PROJECT NO. PR-2020-004820

Application No. SI-2020-001468

DESCRIPTION: Updated site plan set, comment response memo, current infrastructure list, and supporting exhibits.

To: Jolene Wolfley and DRB Members, City of Albuquerque
From: Michael Vos, AICP, Consensus Planning, Inc.
Date: April 15, 2021
Re: Hotel Circle Ramada Apartment Conversion DRB Update (PR-2020-004820)

SHEET NUMBER:

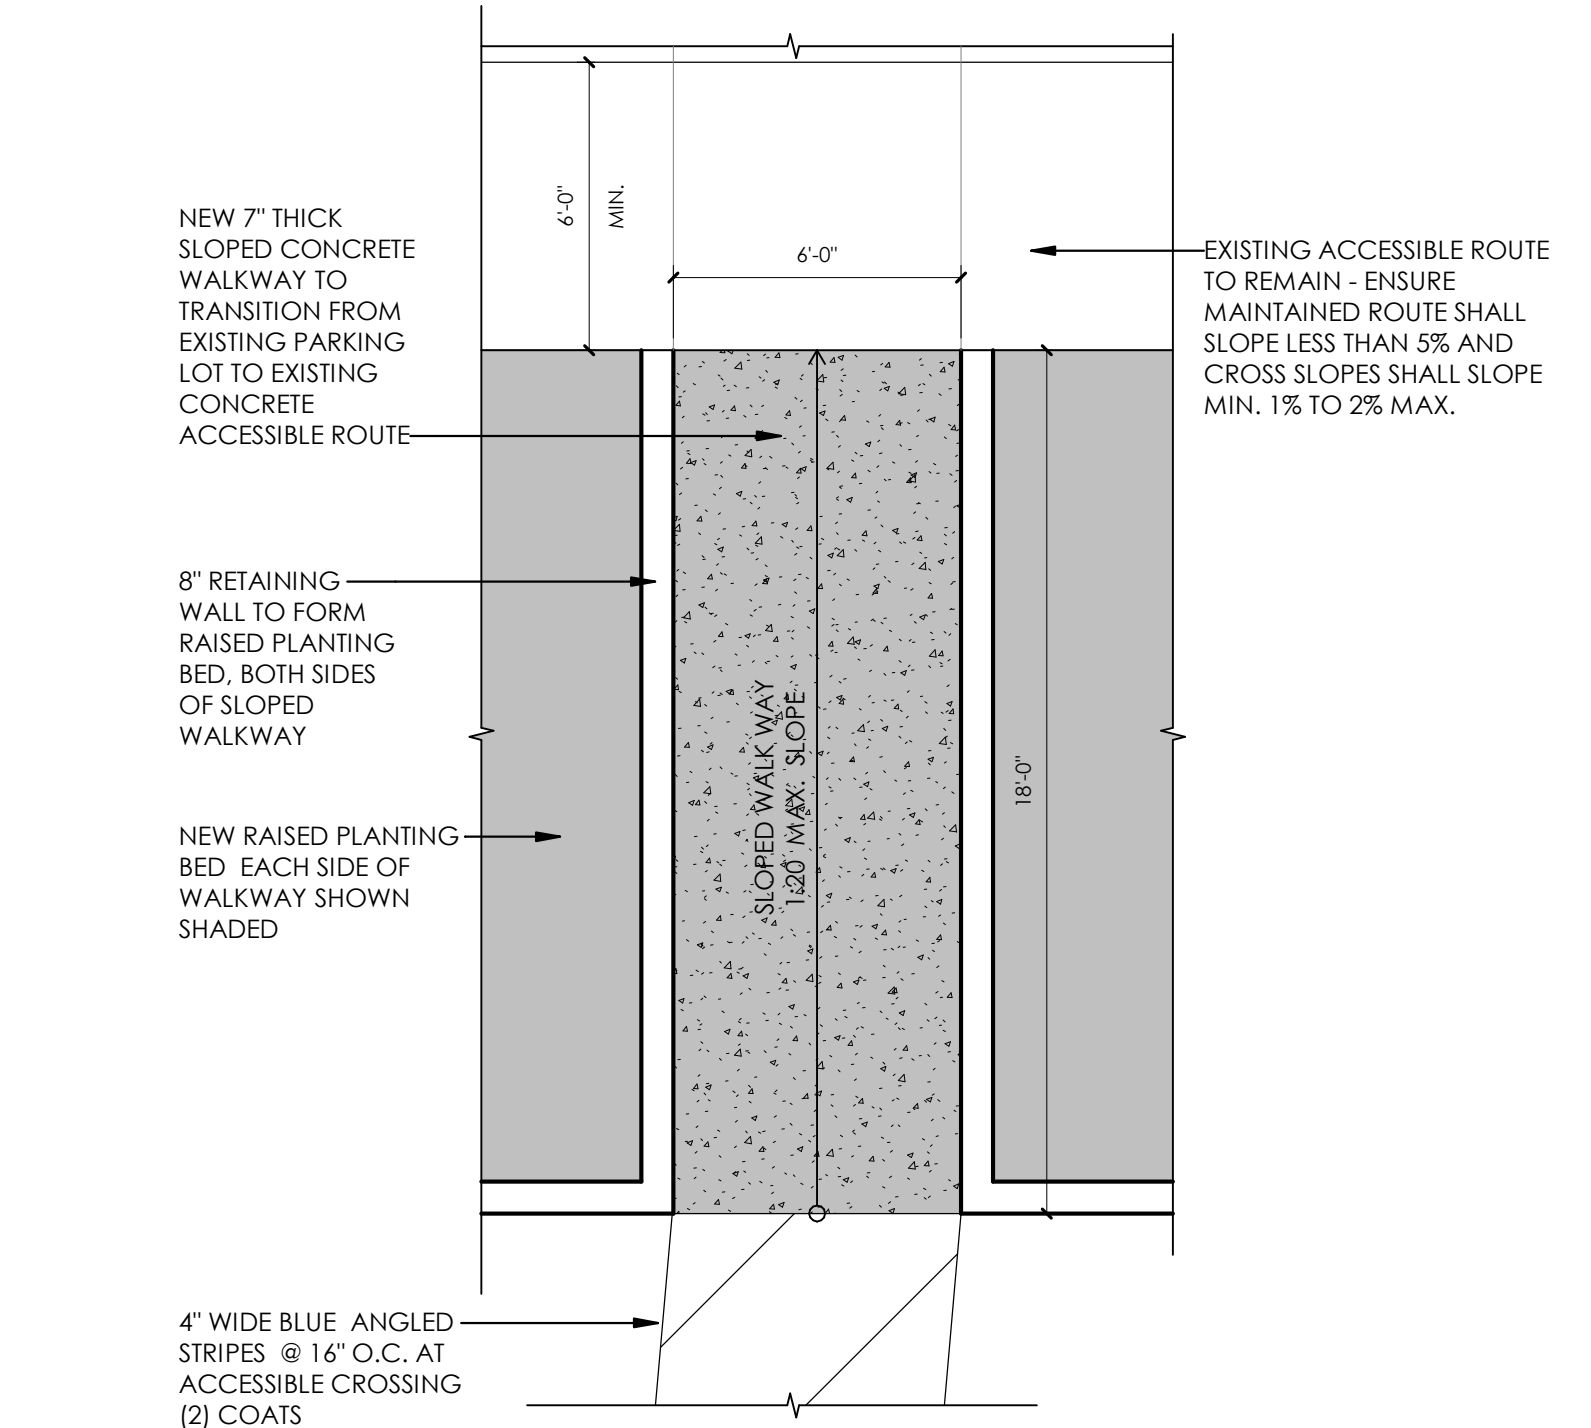
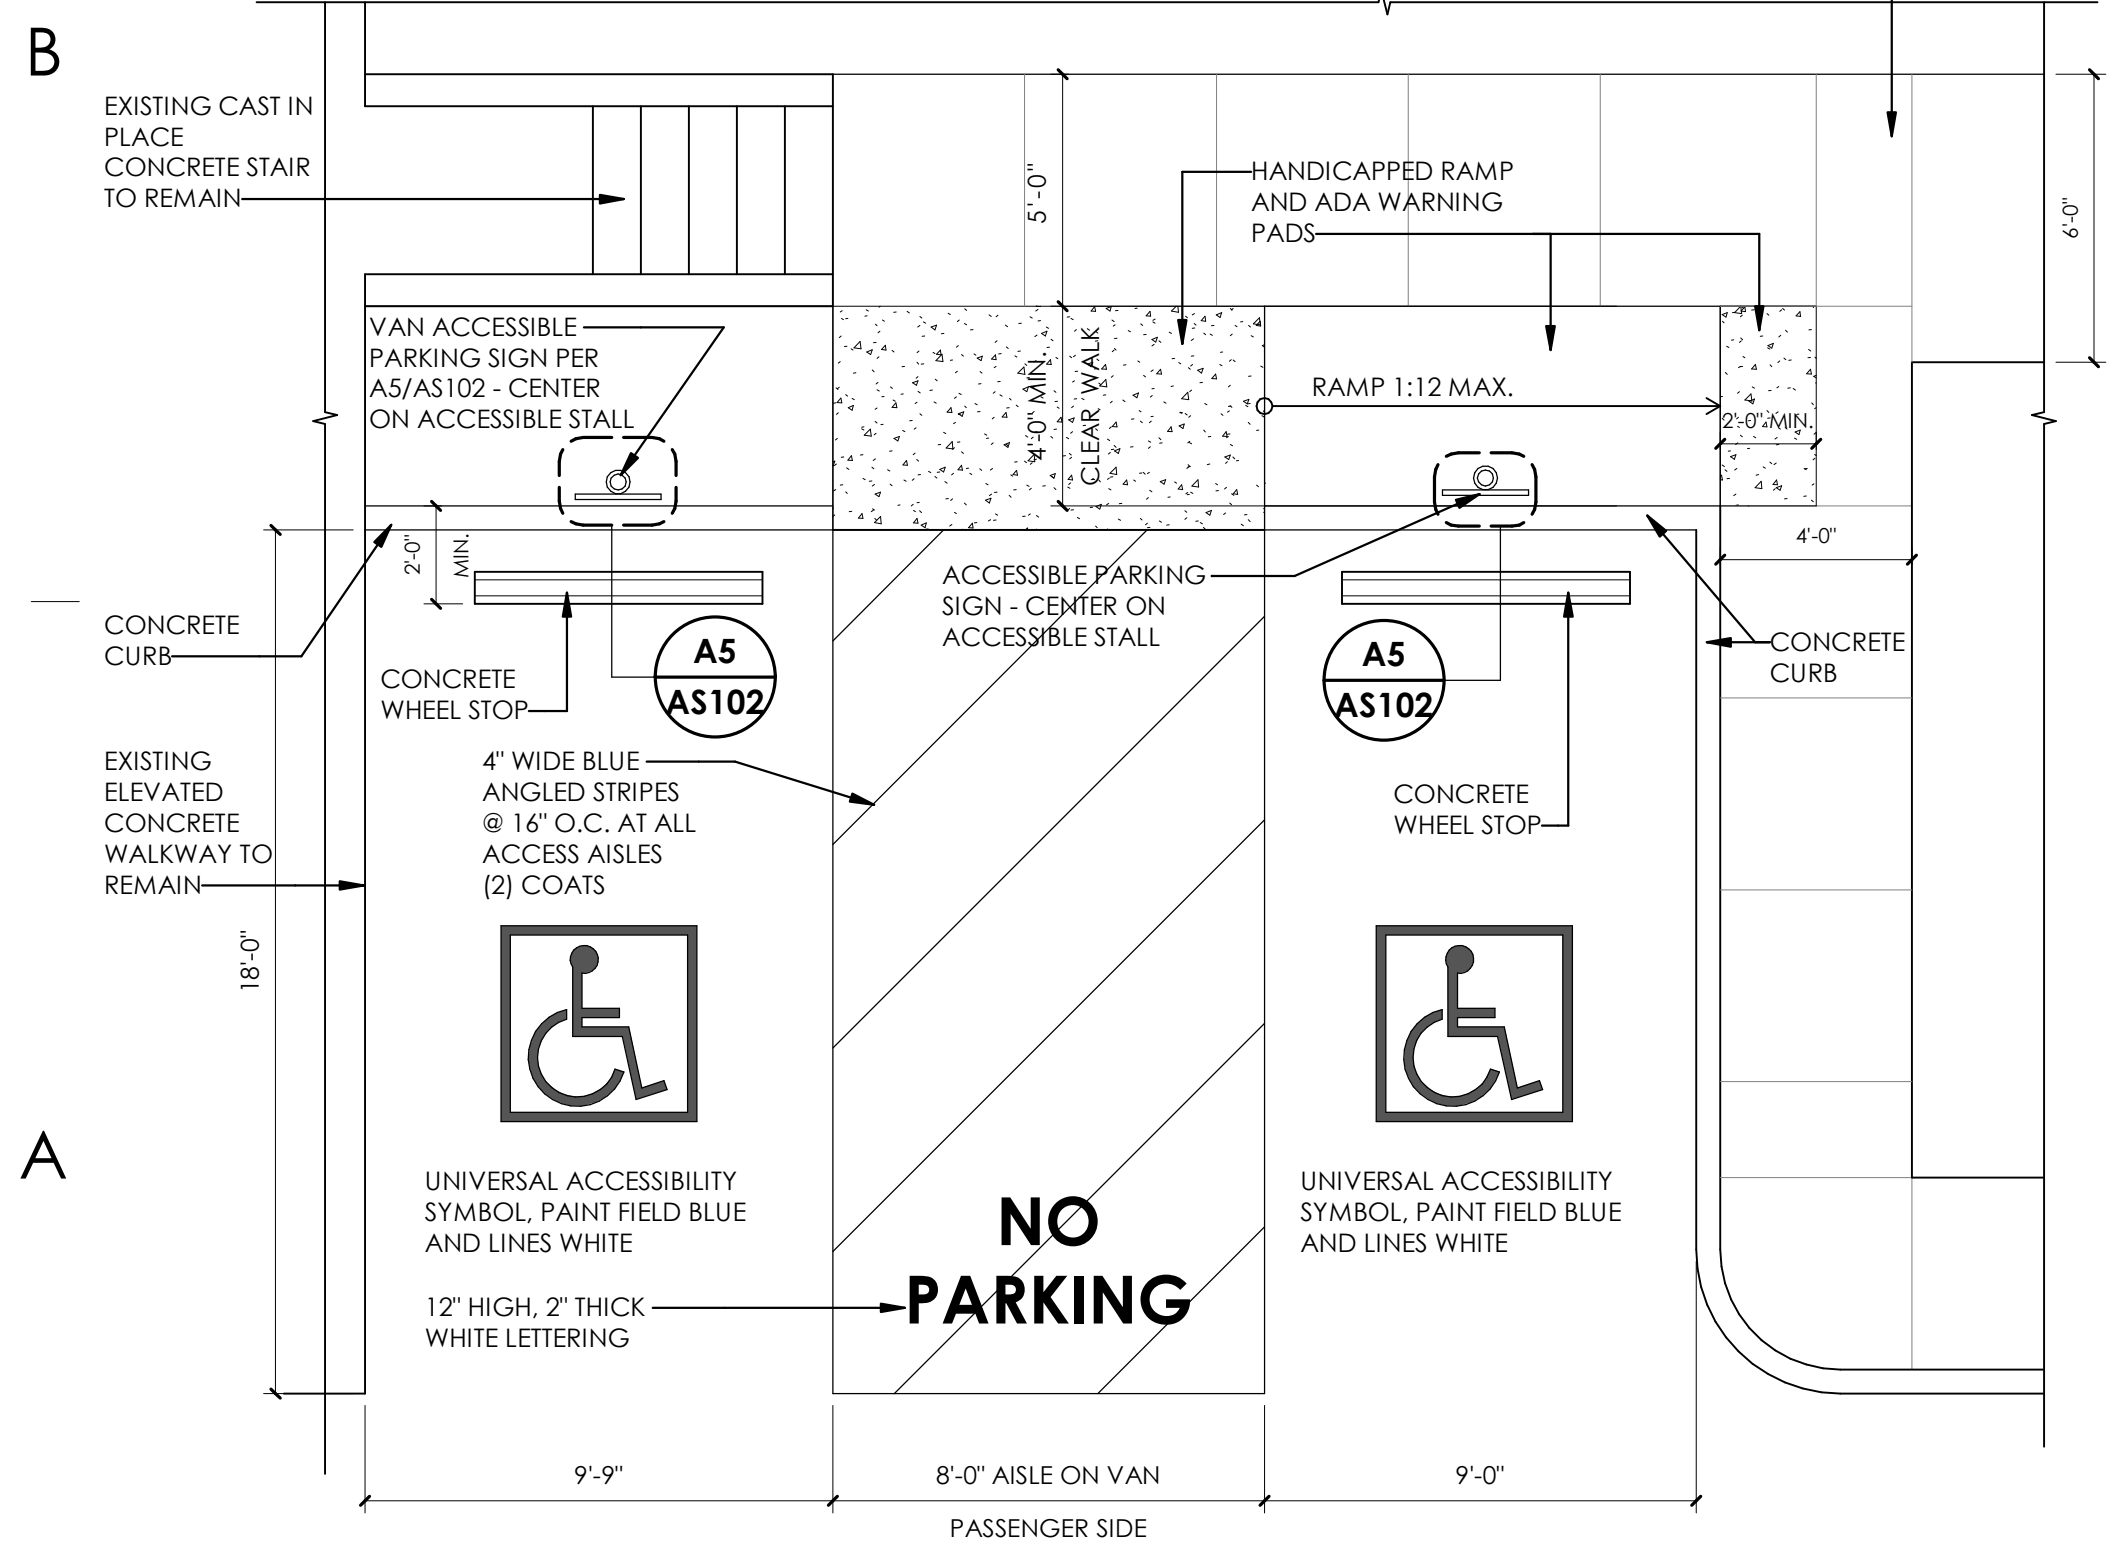
- a. The parking spaces were clarified to identify all 8 required spaces more clearly.**
4. There is a B4 in the details but not on the site plan.
 - a. The detail reference for the ADA space on the east side of the site has been updated to correctly reflect this detail.**

- a. Detail updated.**
6. At B4/103, at the bottom of the ramp that is parallel to the aisle should have 2% maximum cross-slope labeled in both directions for wheelchair turning. Same applies for B2.

- a. Detail updated.**

**A1 SITE - ADA CURB RAMP LOCATION 3**  
1/4" = 1'-0"

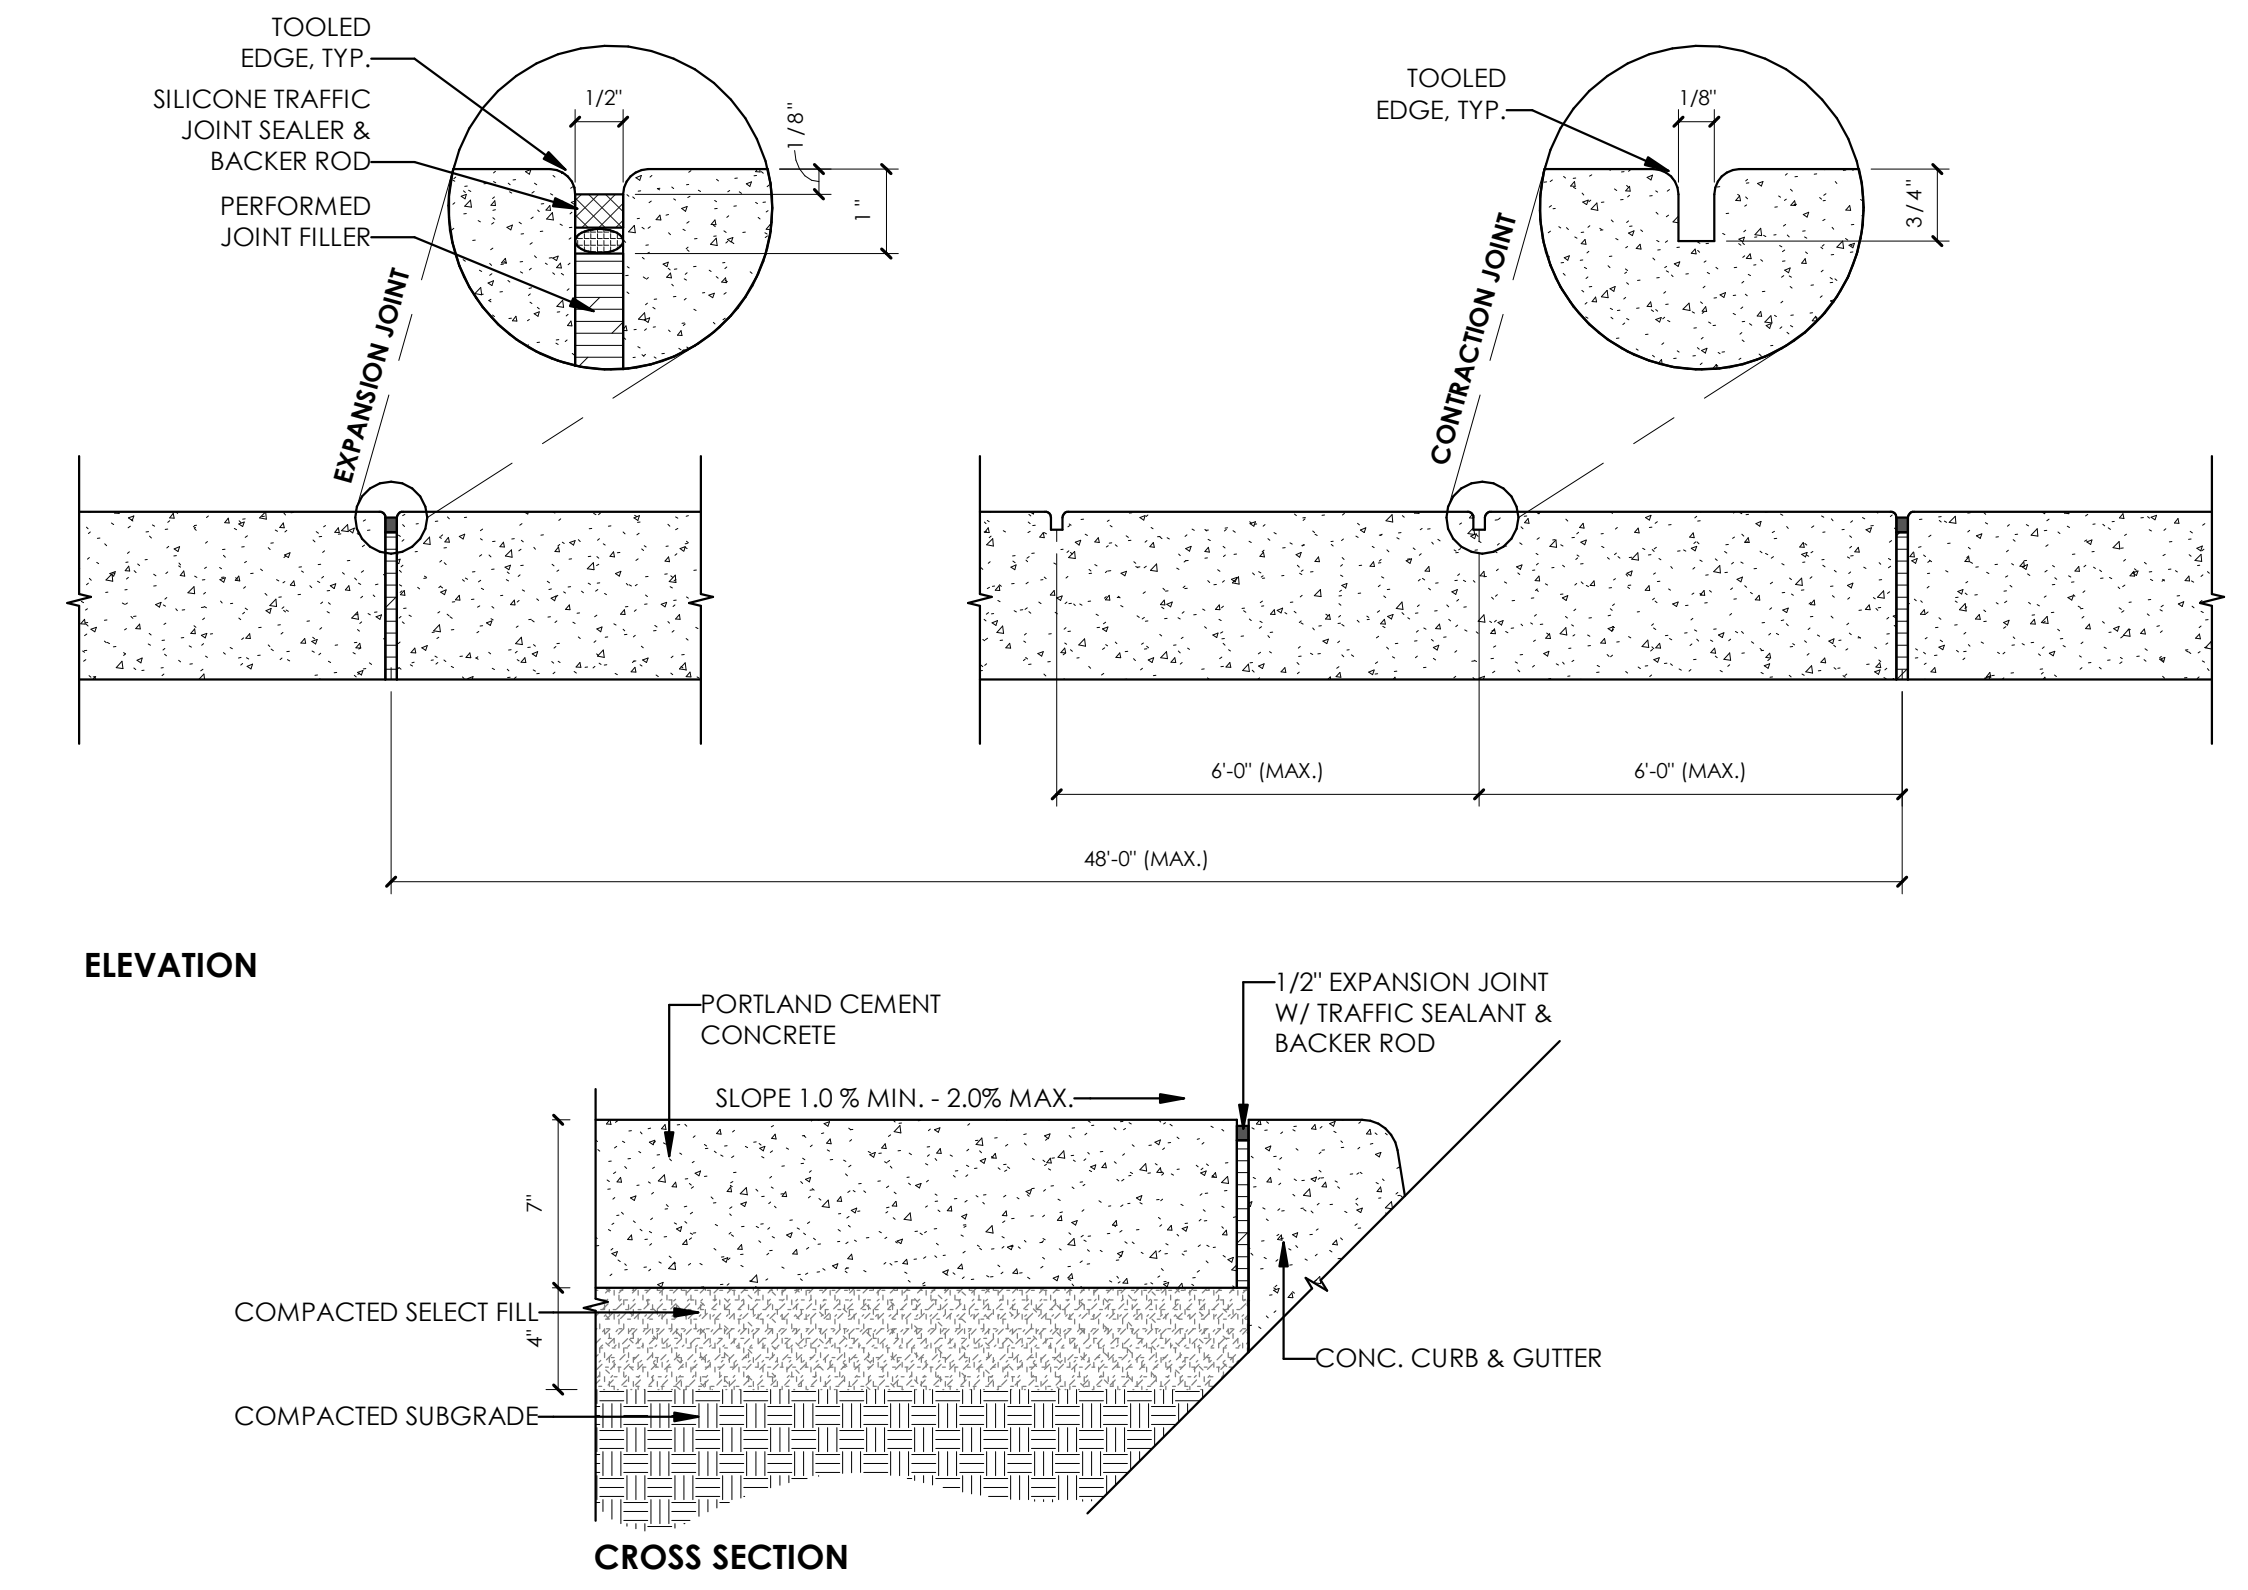
3. The required number of handicapped spaces is 8, but the number shown on the plan is 7. (On the details it implies that there is more than what is shown on the site plan at notes for A1/103.) Maybe this is where the discrepancy is. Clarify for both details.

5. At A1/103, there needs to be header curb labeled where there is a grade difference in the sidewalk alongside the ramp. This also applies to detail B4.
